Planning Application No: 3/2026/0381

Proposal: Proposed two-storey side extension, single-storey rear extension, alterations to roof to accommodate an additional storey, material alterations to the facades and a new relocated site entrance.

Location: Hunters Gate West Bradford Road Waddington BB7 3JE

1 PROPOSED SITE PLAN
1 : 150

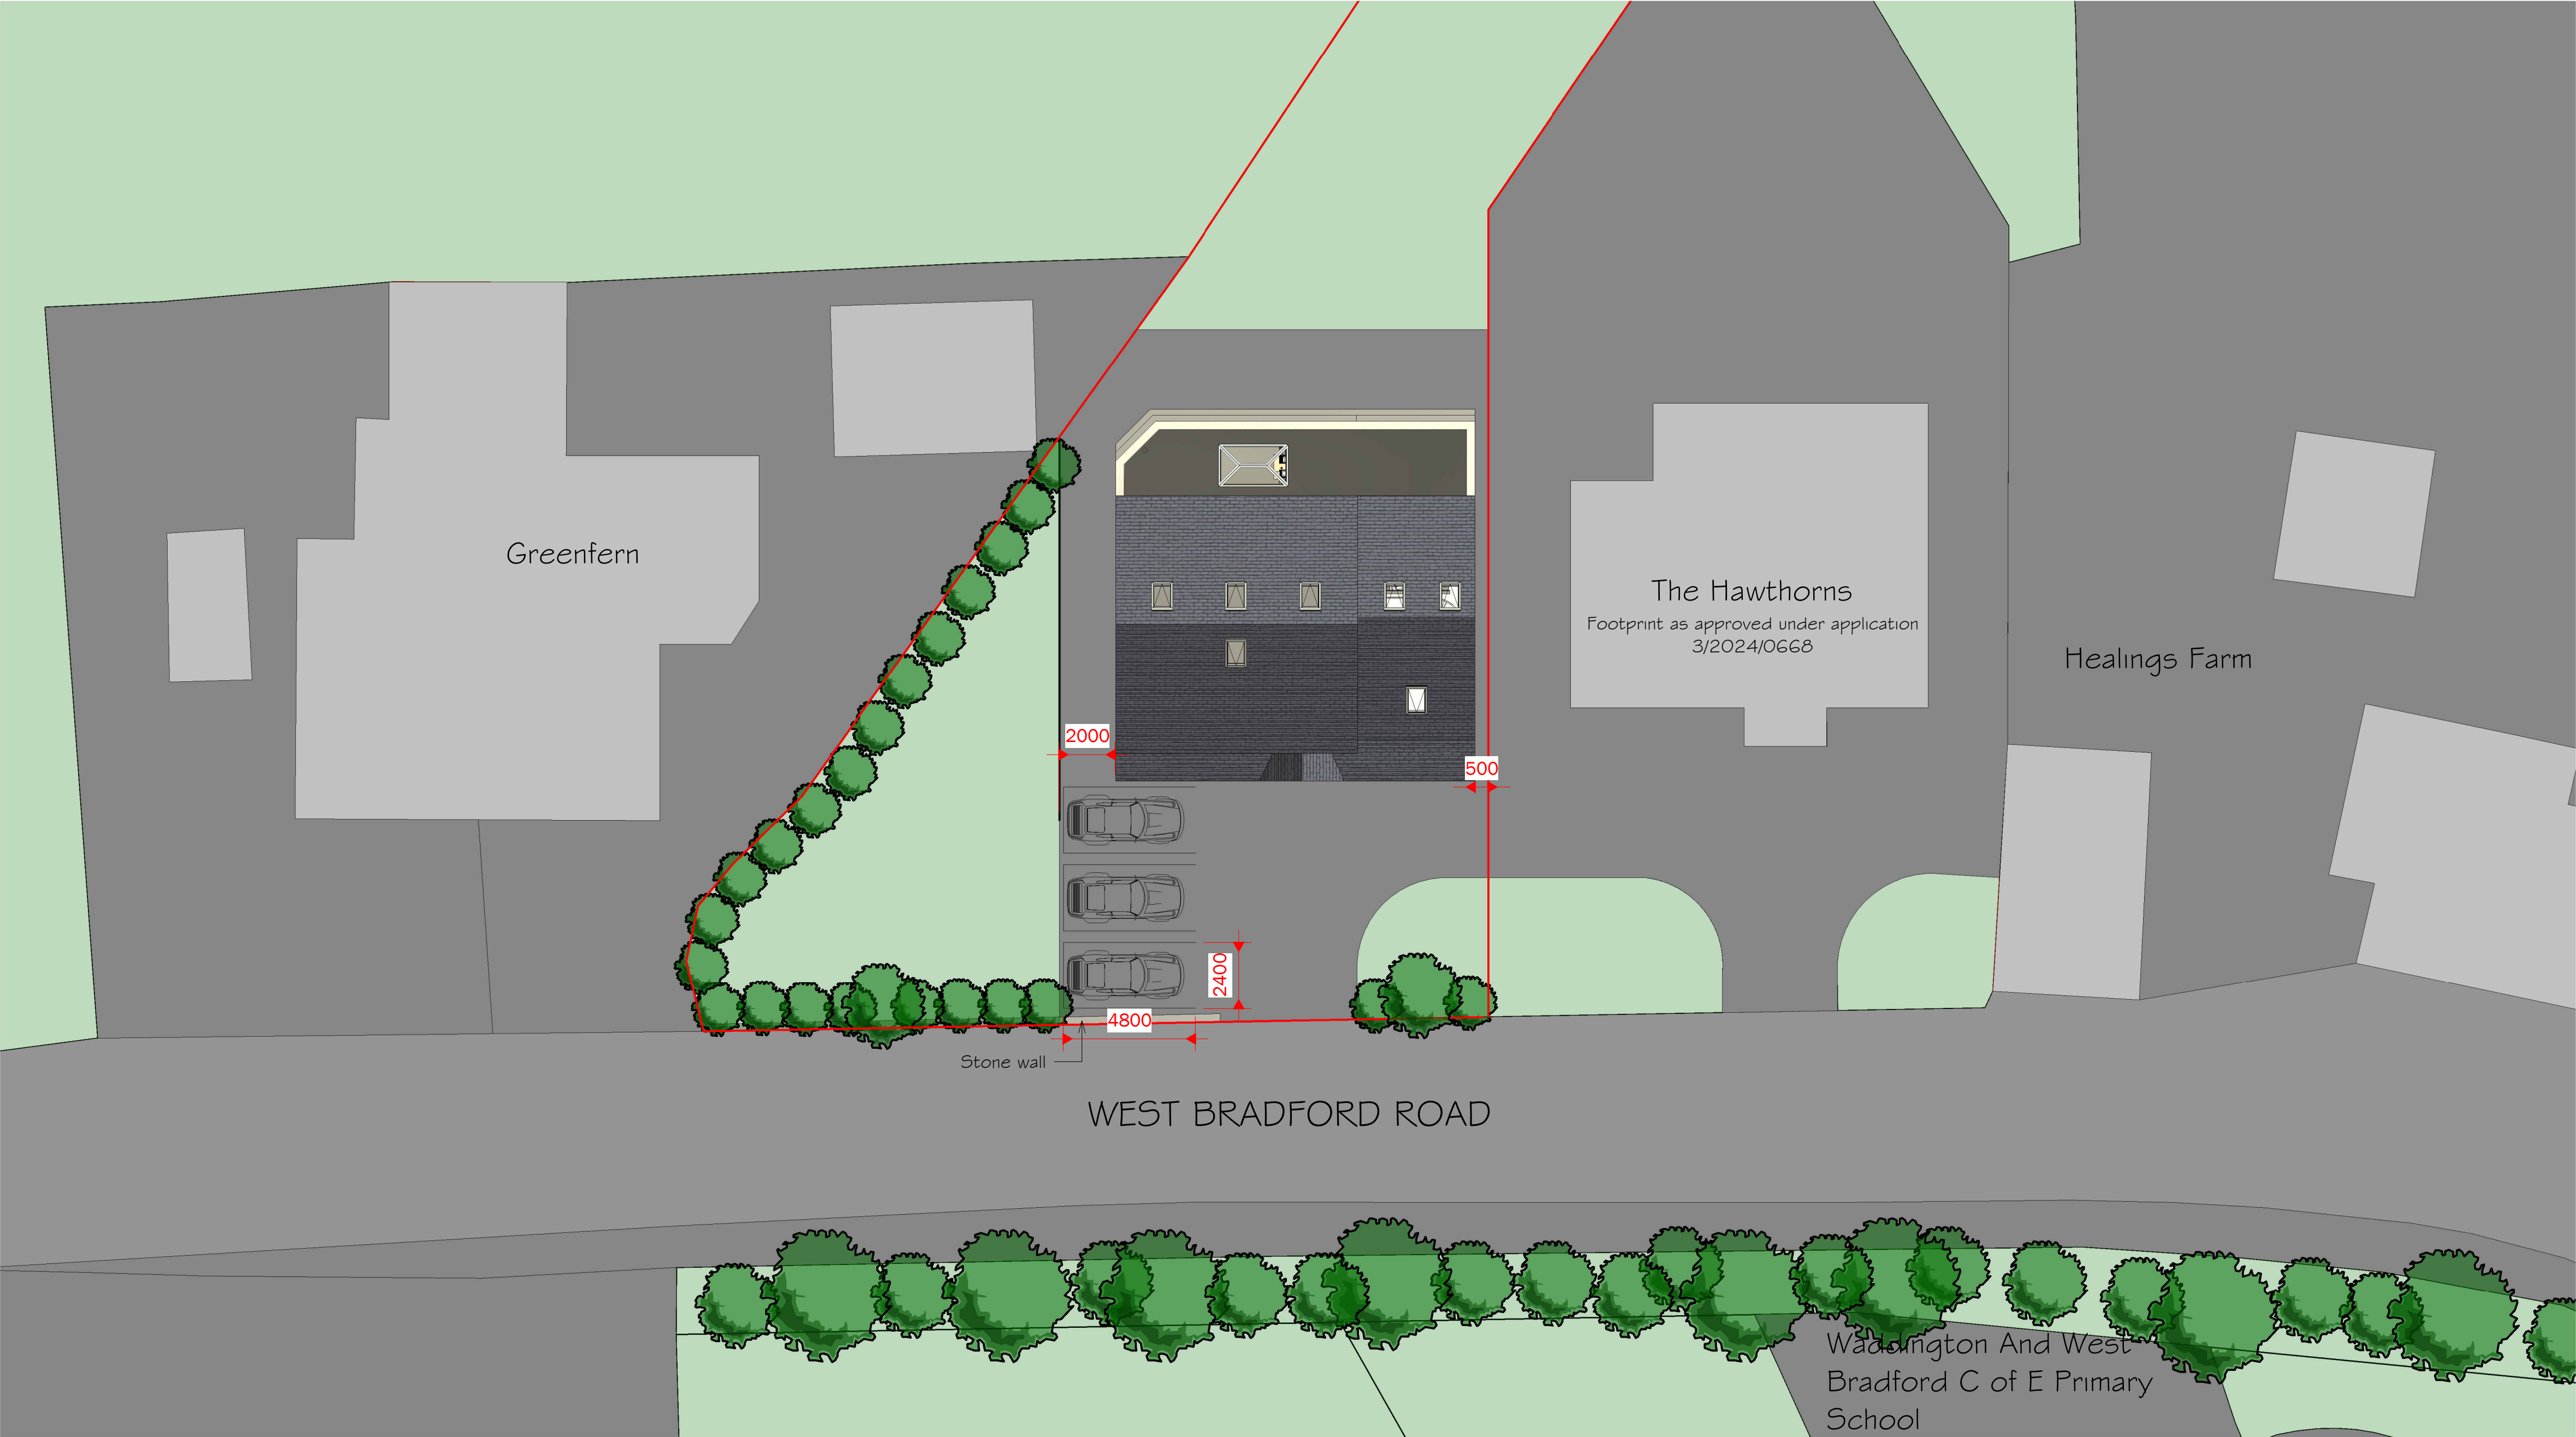
As a new vehicular access is being proposed ref. Proposed site plan, then the informative note below must be adhered to.

- This consent requires the construction, improvement or alteration of an access to the public highway. A list of approved contractors only, can undertake the approved works under the Highways Act 1980 Section 171. Before any work begins at the site, please contact highways@lancashire.gov.uk for the list of approved contractors and to start the section 171 process.
